Helios EN010140

Reg 20050592

**Expanding from my published submission, 28 February 2025. Updated 18/03/2025 with Questions.**

## **The Battery Energy Storage System (BESS) plus the 132Kv Sub Station**

Environmental Statement Figure 11.4: Noise Contour Map Daytime

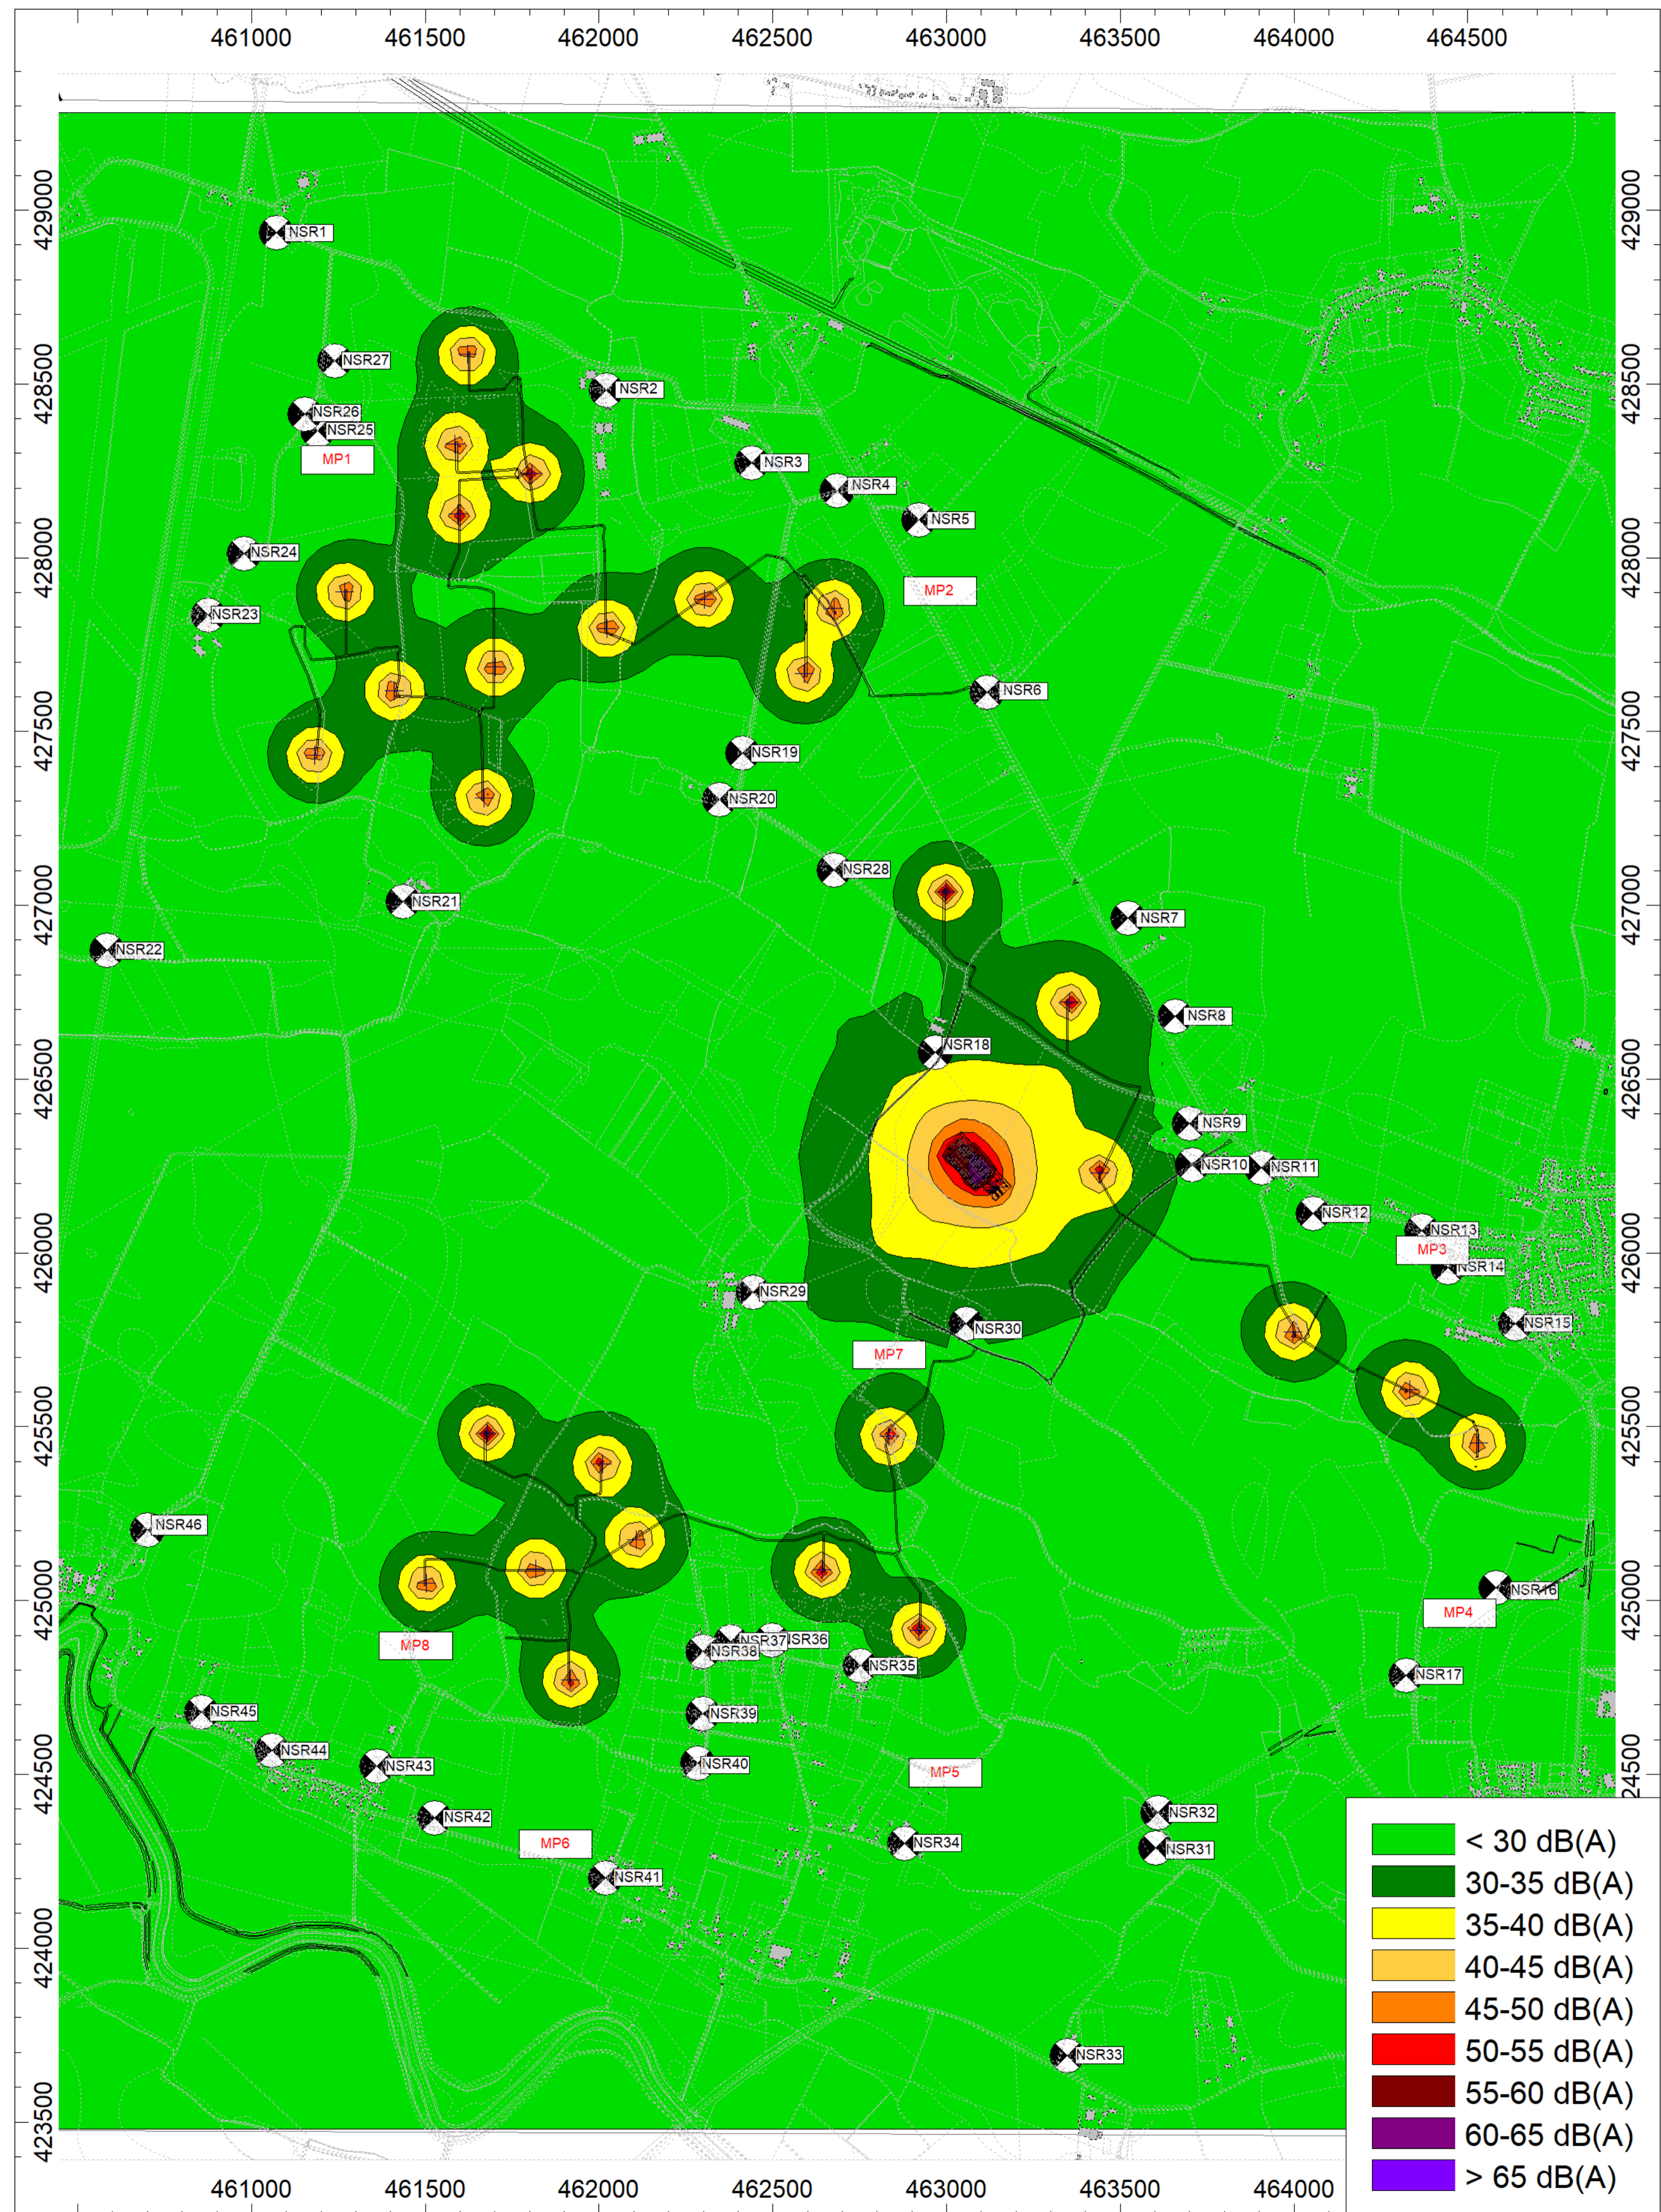
### **With Reference to Environmental statement Figure 11.4**

**(The map I have supplied number 7), has a symbol Z? which I have added. Whatever it/they are. (counted 28) They have the capability of emitting 45-50 dB of noise. The Z? in question is ALMOST AT THE BOTTOM OF MY GARDEN.**

**Due to the poorly detailed map, I could not get a Fix position to measure approx., how close it is.**

**1.a What are these? And do the Planning Inspectorate know?**

## Also With Reference to Environmental statement Figure 11.4

On the poorly detailed Map Fig 11.4 – Noise Contour Map Daytime, (my ID Map 7). I would like some independent assurance, that *as if by some miracle*, we are in the < 30 dB zone.
